Our Ref: BN/103/19/CLP

**Town & Country Planning Act 1990 (as amended)
Town & Country Planning (Development Management Procedure) (England) Order 2015 - Article
39
Application for Certificate of Lawfulness for a Proposed Use or Building**

Development Lawful development certificate for a proposed garage conversion.
Location 34 Lapwing Grove Barnham

existing Ground Flr
Front elevation.

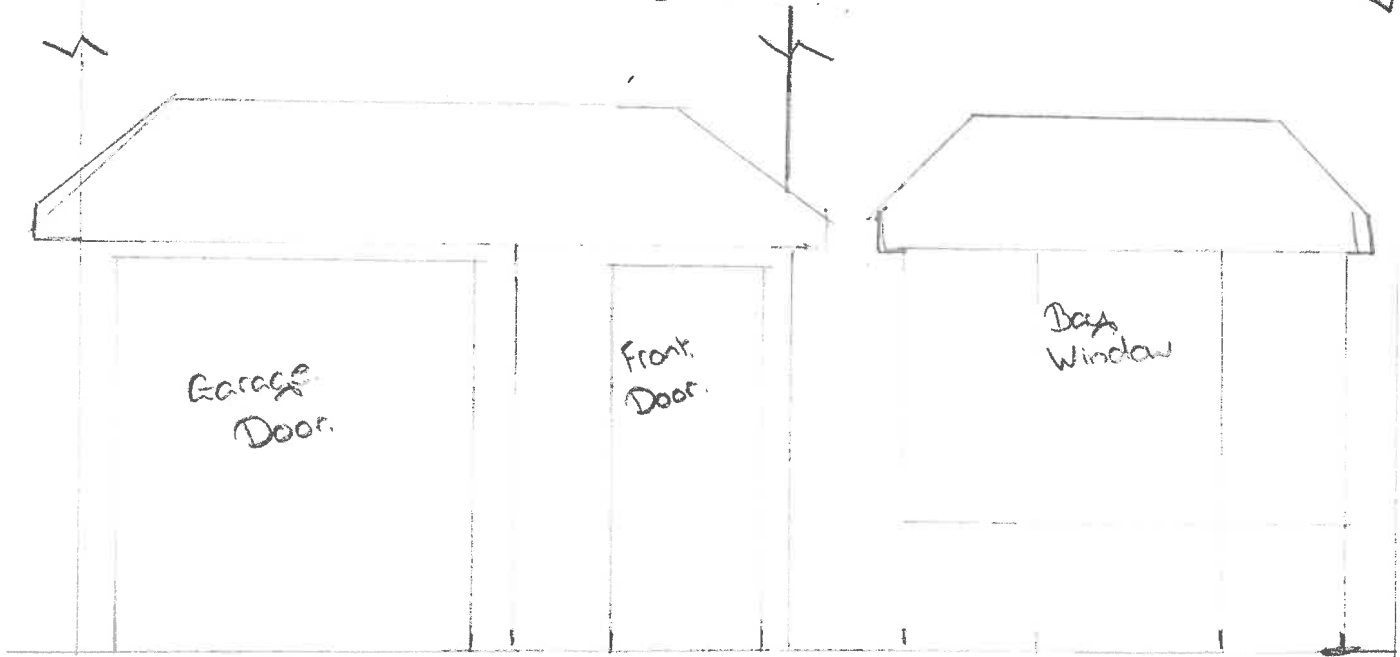
Existing and Proposed Front Elevation - please provide plans to scale or the measurements in metric.
